File No: NTH09/01728/05
Your Ref: SSD_7198

Response to Submissions – Moonee Parklands 103 Lot Residential Subdivision and Associated Infrastructure (SSD_7198) Lot 1 DP 1097743, Pacific Highway, Moonee Beach

31 May 2016

**Figure 18 Access to site via Lot 6 from Court approved collector road**

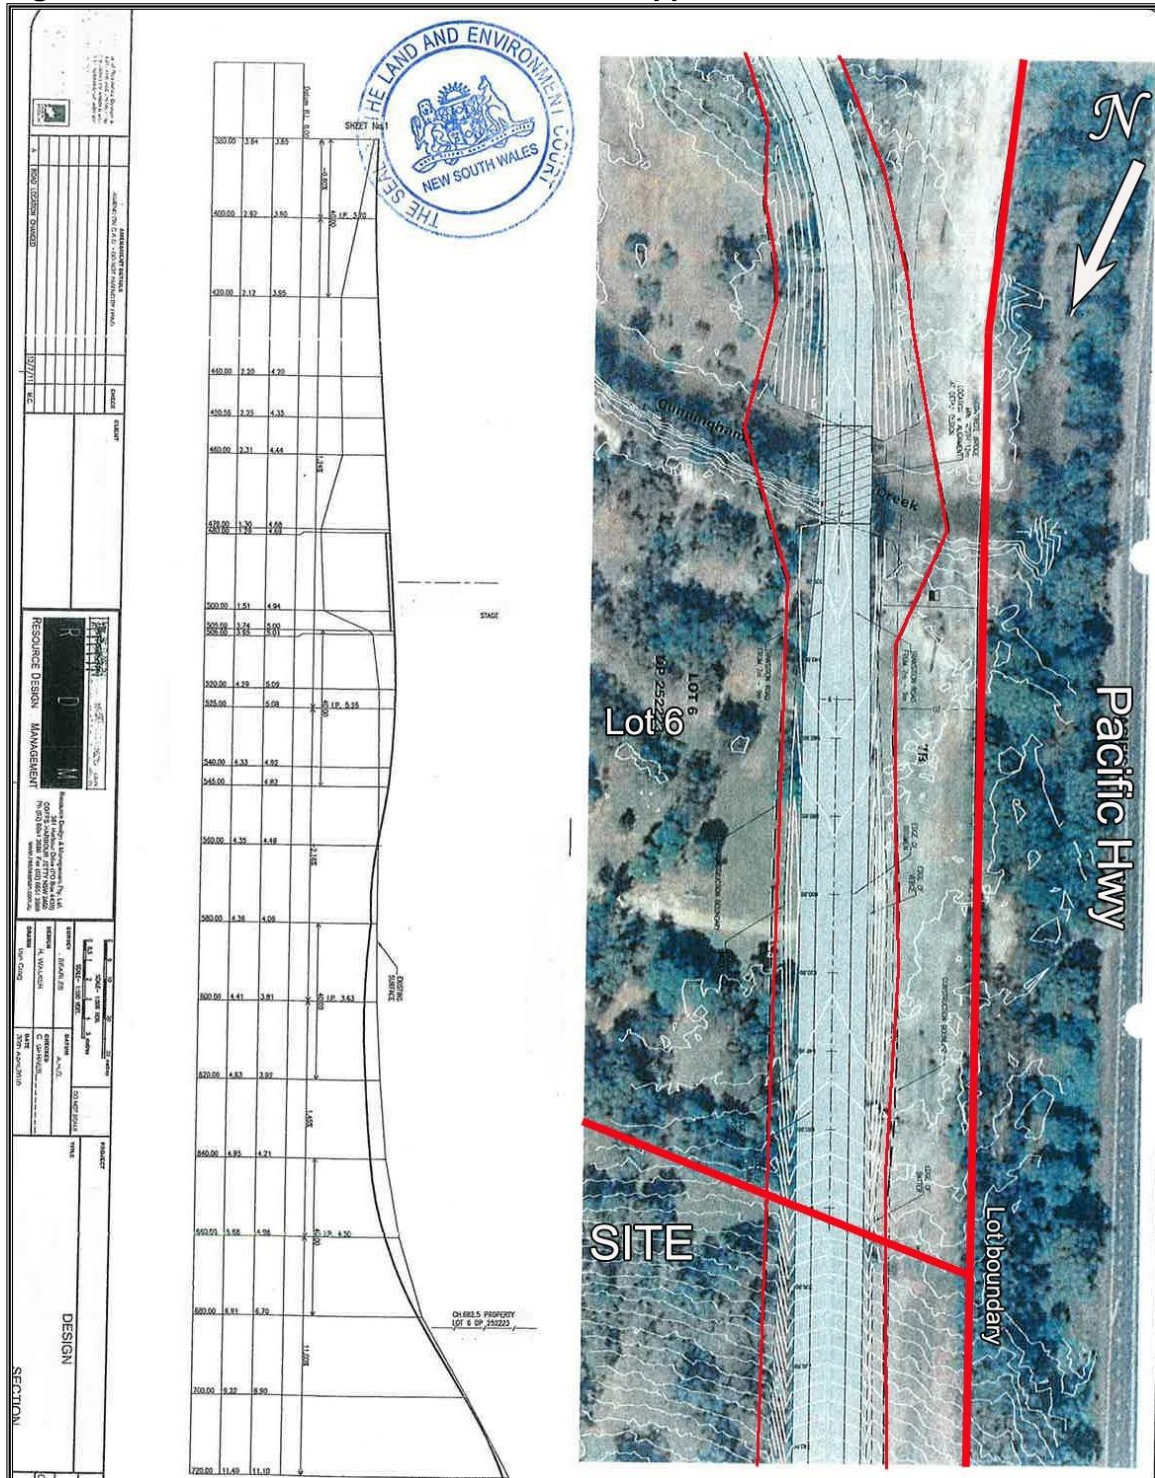
1. Section 3.10 includes a request for a condition to be provided in the project approval to ensure the construction and dedication of the collector road prior to the issue of a subdivision certificate. It is noted however that the wording only requires construction of that part of the service road that is over the subject site. Additionally, the condition should be expanded to require the connection of the service road to the local road network prior to the issue of any subdivision certificate.

2. Roads and Maritime reiterates the requirement that all future operational traffic from the subdivision must access the Pacific Highway via the local road network and the Moonee Beach Road interchange. No direct access to the highway for operational traffic will be supported. The existing left in / left out temporary construction access must be physically and legally closed prior to the issue of any subdivision certificate for this development.
